The Coal
Authority

Re: Planning application 2024/62/92910/E

Demolition of dwelling and barn and erection of two dwellings with associated external alterations at Land adjacent 45 Coal Pit Lane, Lower Cumberworth, Huddersfield, HD8 8PL

The Coal Authority response: MATERIAL CONSIDERATION

Proposed site plan (1:200)

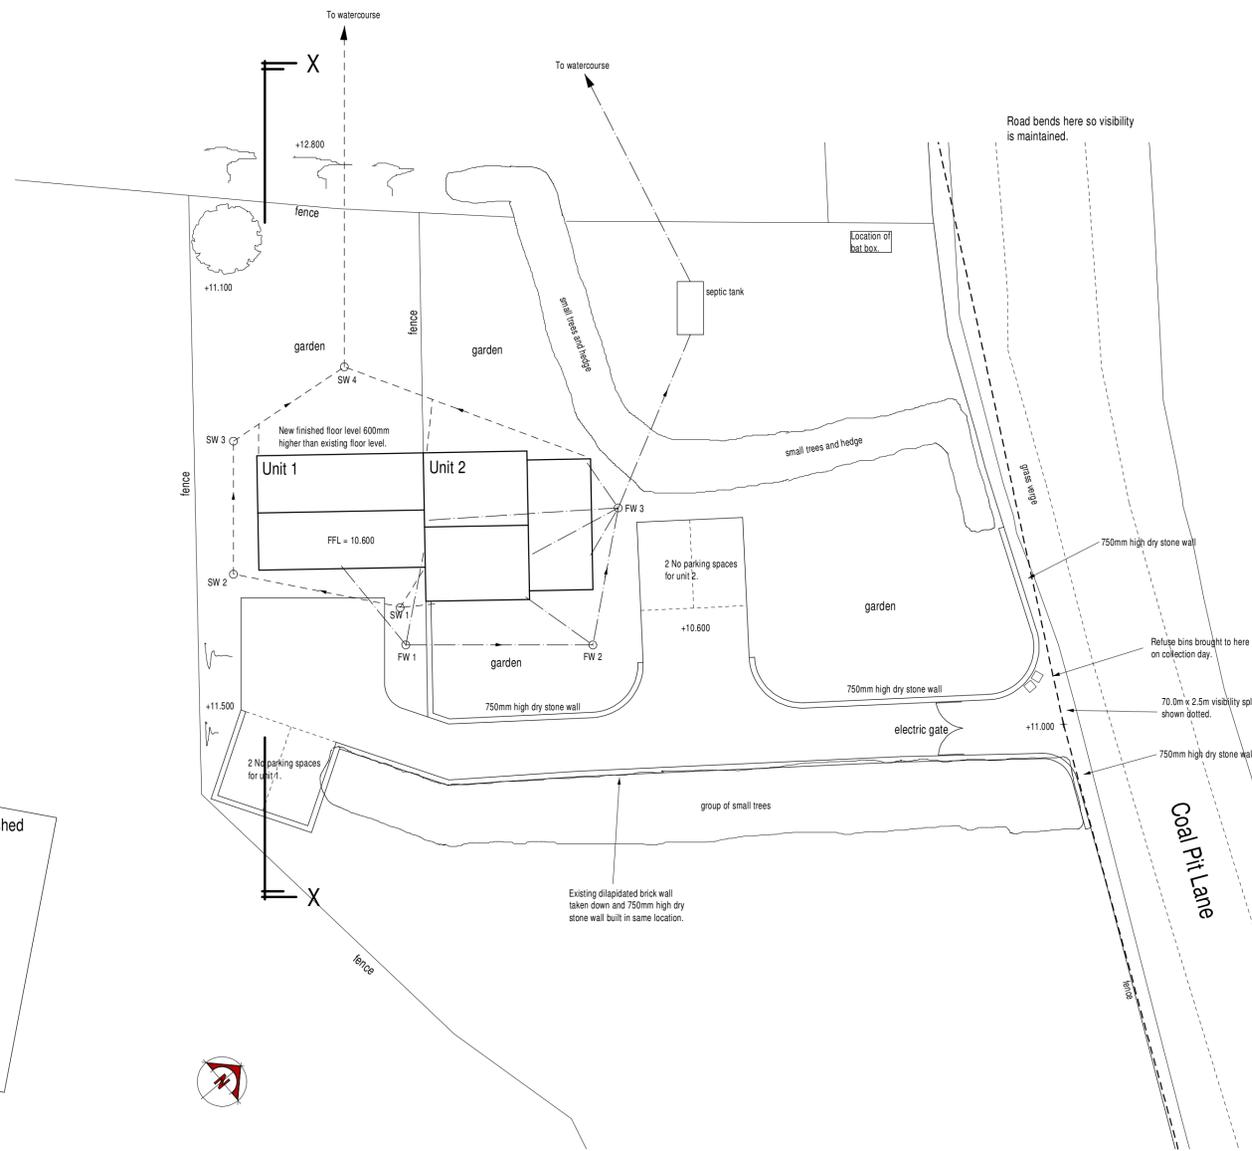
The Coal Authority records indicate that the zones of influence of two recorded mine entries (adit, CA ref. 421409-024 and shaft, CA ref. 421409-052) encroach into the south western and north eastern parts of the application site respectively. We hold no details of any treatment of these features and, due to potential plotting inaccuracies, the actual

positions of the mine entries could deviate from their plotted positions by several metres. As such, the adit could potentially be located within the southern part of the site, close to proposed Unit 1. An untreated or inadequately treated mine entry and its resultant zone of influence pose a significant risk not only to surface stability but also public safety.

Mr Palmer indicated that recorded off-site mine shaft 421409-052 located to the north of the site poses a low risk to the proposed development. However, he acknowledged that recorded adit 421409-024 could potentially be present within the site. He also acknowledged that the potential zone of influence of this feature extends into the site. As such, he considered that this feature poses a moderate risk to the proposed development.

Mr Palmer went on to recommend that intrusive site investigations should be carried out within the application site, adjacent to the southern boundary, in order to prove/disprove the presence of the adit within the site and to inform any necessary remedial measures.

- ***No development (excluding the demolition of existing structures) shall commence until intrusive site investigations have been carried out to establish the presence or otherwise of recorded adit 421409-024 within the application site. The findings of the intrusive site investigations shall be submitted to the Local Planning Authority for consideration and approval in writing. The intrusive site investigations shall be carried out in accordance with authoritative UK guidance.***

- ***Where the findings of the intrusive site investigations (required by the condition XX above) identify that recorded adit 421409-024 poses a risk to surface stability, no above ground development shall commence until a detailed remediation scheme to protect the development from the effects of such land instability has been submitted to the Local Planning Authority for consideration and approval in writing. Following approval, the remedial works shall be implemented on site in complete accordance with the approved details.***
